CHAMPIONS QUARRY

Minor Operational Changes Modification (PA 09_0080 MOD 2)

Environmental Assessment Report

Plan of Biodiversity Offset Areas

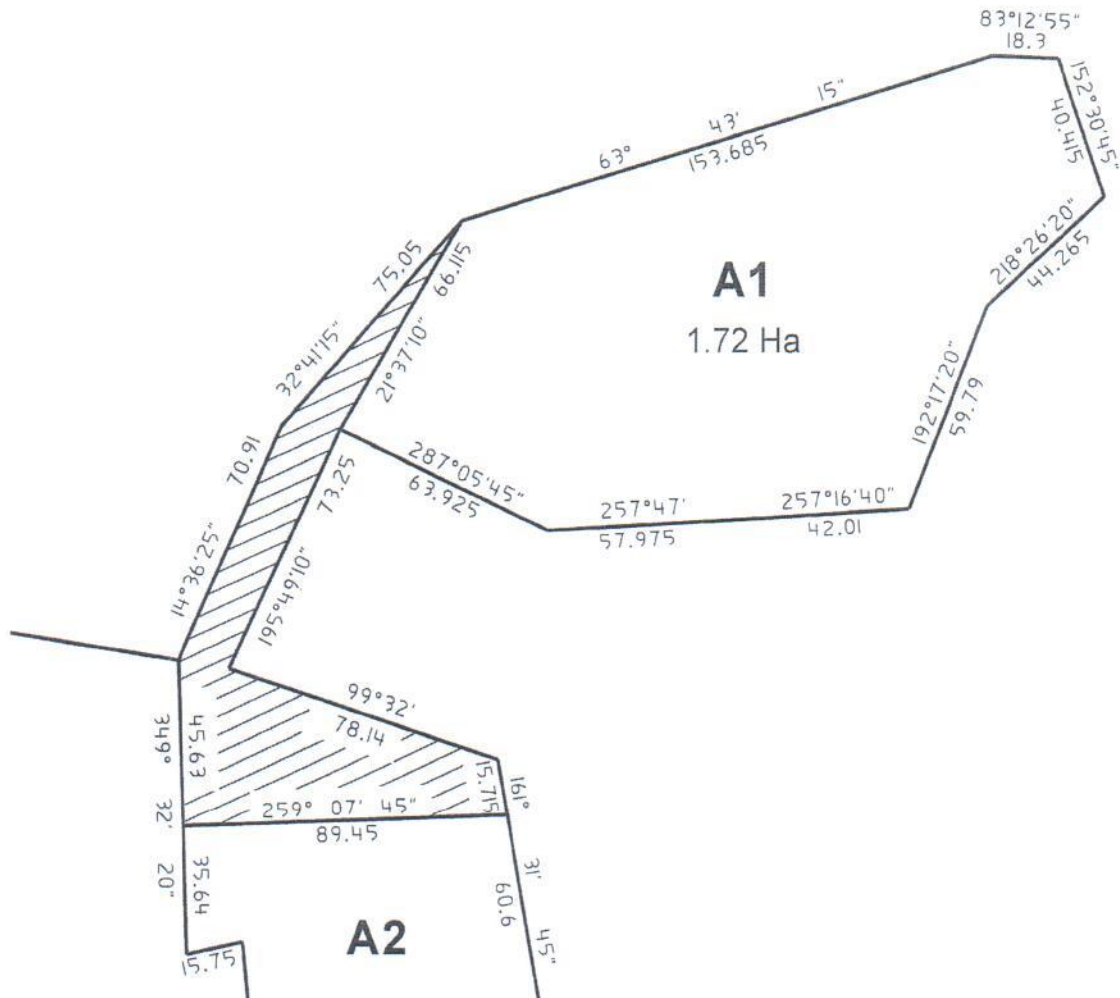
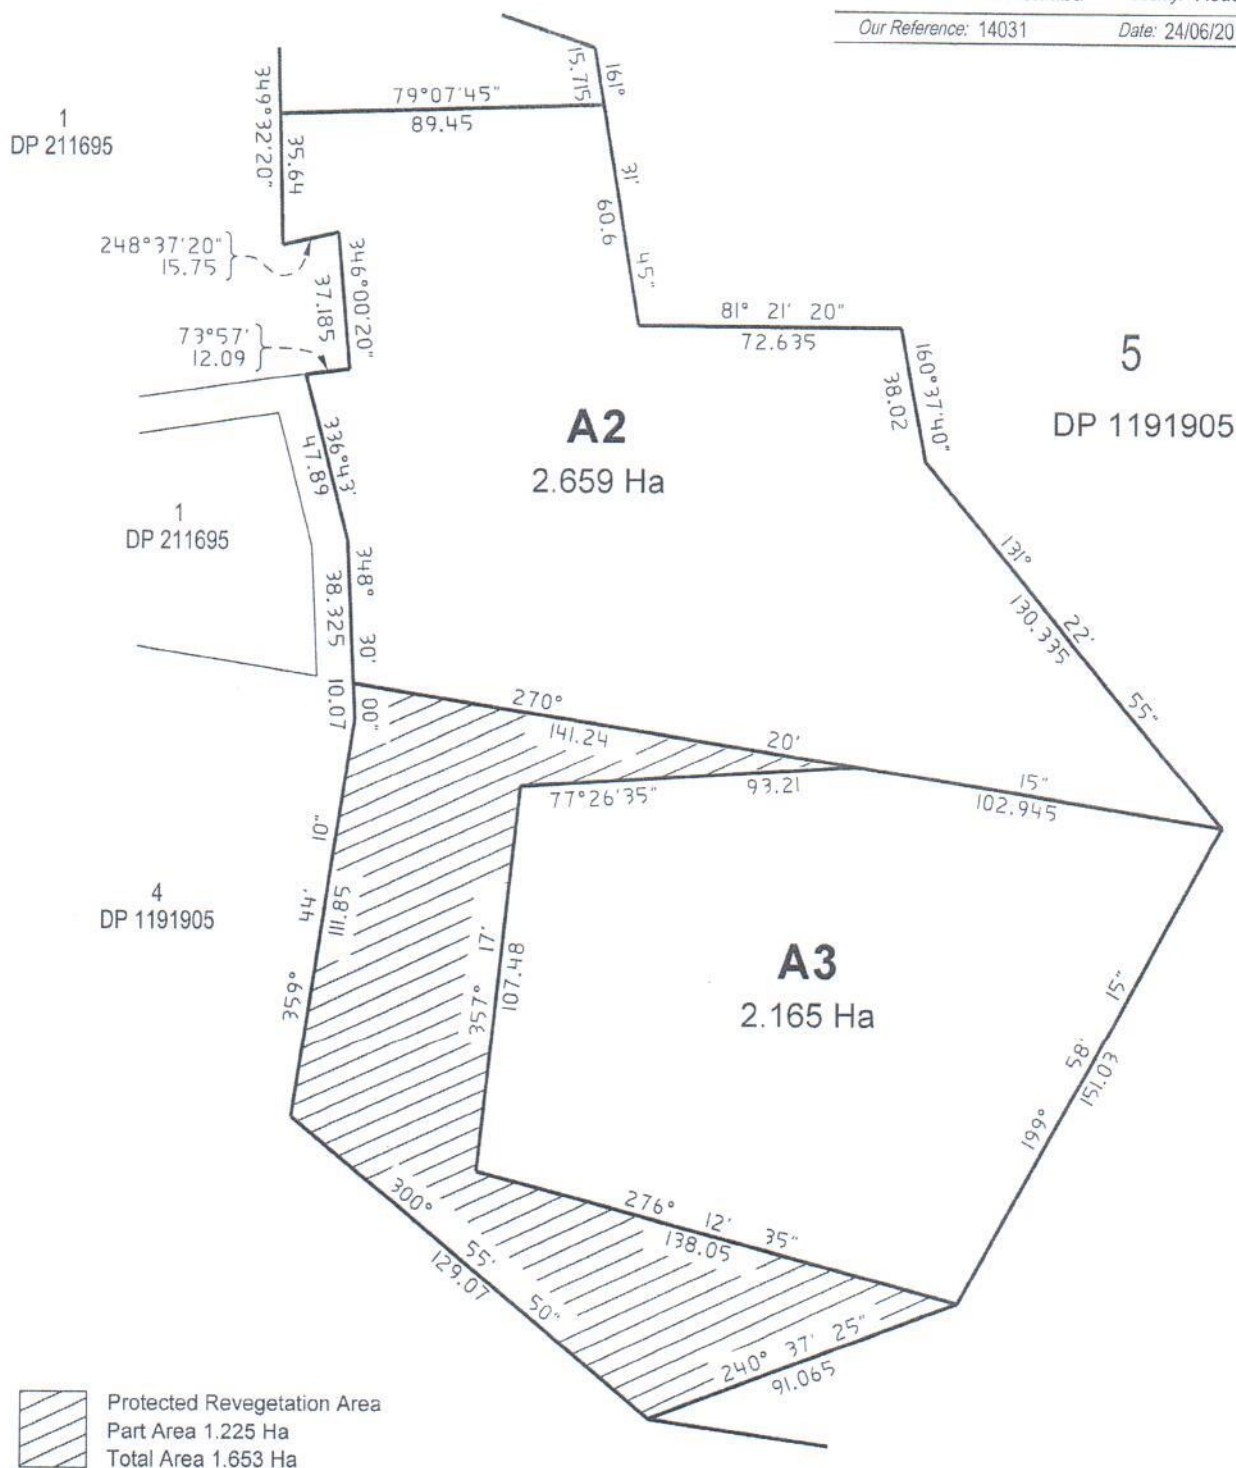
Champions also requested that the figure in Appendix 6 of the project approval be replaced with an updated figure that includes revised boundaries for the Biodiversity Offset Areas that have been ground-truthed and surveyed. Table 7 in condition 40 identifies the area shown in the current figure in Appendix 6 as being conceptual. Champions provided an updated figure with boundaries for the Biodiversity Offset Areas that it claims reflect the vegetation on the ground at the date of survey, which has varied since the areas were originally identified in 2010. Champions has stated that the revised areas satisfy the minimum size requirements contained in Table 7. Champions provided further demonstration of this calculation in its RTS by way of survey drawings. These confirm that the proposed boundaries satisfy the area requirements of Table 7.

However, in reviewing the revised boundaries overlaid on the aerial photo (see **Figure 3**), it can be seen that Champion's revised boundaries would result in less high density/quality vegetation and a greater area of lower density vegetation in the proposed Biodiversity Areas 1, 2 and 3. Conversely, the proposed Protected Revegetation Area would contain high density/quality vegetation and less low density vegetation. This is contrary to the intent of the offset areas and is inconsistent with Champions' claim that the revised boundaries are in part the result of ground-truthing current vegetation.

During discussions with Champions it was confirmed that the revised boundaries for the offset areas were also based on its proposal to provide offset areas that could be efficiently fenced (as stated in the modification application). In so doing, Champions proposed to make maximum use of existing fencing and to maintain a 50 metre (m) buffer between the offset areas and the quarry extraction area. Champions interpreted that providing the 50 m buffer to the offset area boundary would satisfy Schedule 3 condition 37 which requires "*that the edge of the Southern Extraction Area is setback at least 50 metres from the mapped Dry Rainforest/Lowland Rainforest EEC on site.*" The Department's position is that a 50 m buffer does not in itself satisfy condition 37 because the buffer needs to be provided to the physical edge of the mapped Dry Rainforest/Lowland Rainforest EEC.

On 6 May 2016, the Department informed Champions that it was not satisfied with the Biodiversity Offset Area boundaries as proposed in MOD 2 and requested that they be revised. On 8 August 2016, Champions provided a figure showing the revised Biodiversity Offset Areas that addressed the Department's concerns (see **Figure 5**). The Department considers that the revised Biodiversity Offset Areas and Protected Revegetation Areas now more closely reflect the conceptual areas identified in Figure 9 in Appendix 6. More of the high density/quality vegetation is now contained in the Biodiversity Offset Areas, the lower density/quality vegetation is now contained in the Protected Revegetation Areas and the minimum size requirements for each area have been either met or exceeded. In fact the proposed revised BOS results in an increase in area protected by 0.653 ha, when compared with that currently required by condition 40.

Figure 2: Location of Internal Haul Road

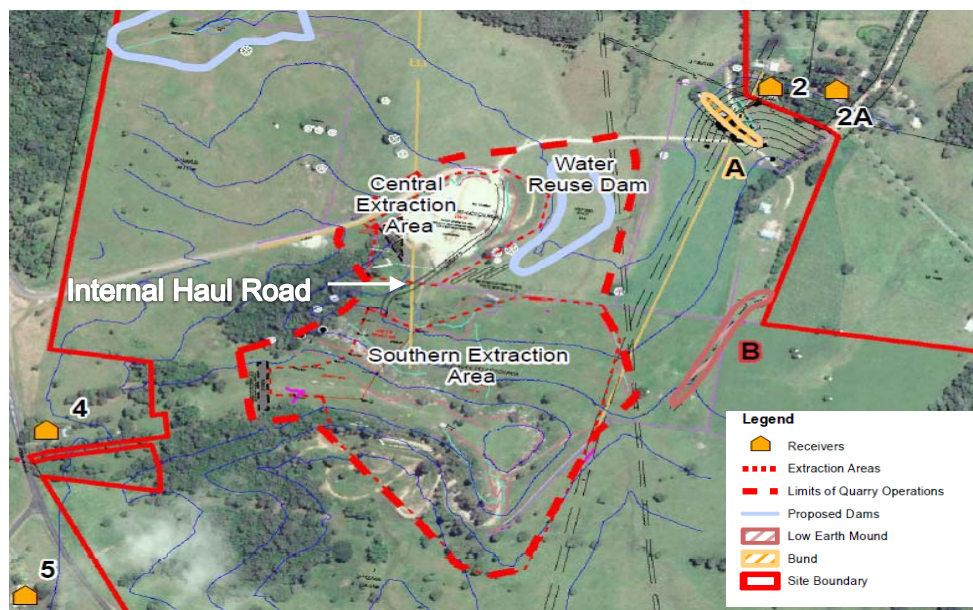
The sealing of the internal haul road between the Central and Southern Extraction Areas was proposed as part of the dust control measures contained in the 2009 project application and EA. Champions has stated that sealing the haul road is impractical as heavy machinery would rip up the seal, resulting in potential contamination of product, and has requested that watering the haul road be allowed as an alternative.

As noted in correspondence dated 13 January 2015 from the Department to Champions Quarry, the Department has previously accepted that sealing the internal haul road would be of little benefit and would likely be damaged by heavy vehicles. The key issue is whether the sealing of the internal haul road is necessary for the quarry to meet air quality criteria and whether watering of the haul road is a satisfactory alternative. As identified in the 2009 EA (see Table C1: Emissions Estimation in the Air Quality Assessment (ERM, November 2009)), the air quality modelling assumed that internal haulage would be on unsealed roads. There were also a number of other factors which led to the model and its predictions being conservative. Nonetheless, the Air Quality Assessment predicted that the quarry could meet all air quality criteria at all private residences. Champions is currently complying with air quality criteria, as detailed in its 2015 and 2016 Annual Reviews.

The Department considers that watering of internal haul roads at a rate of 2 litres per m² per minute is an acceptable method of controlling dust from haul roads. The Department is satisfied that watering the internal haul road between the Central and Southern Extraction Areas as an alternative to sealing the road is a satisfactory and practical method of controlling dust.
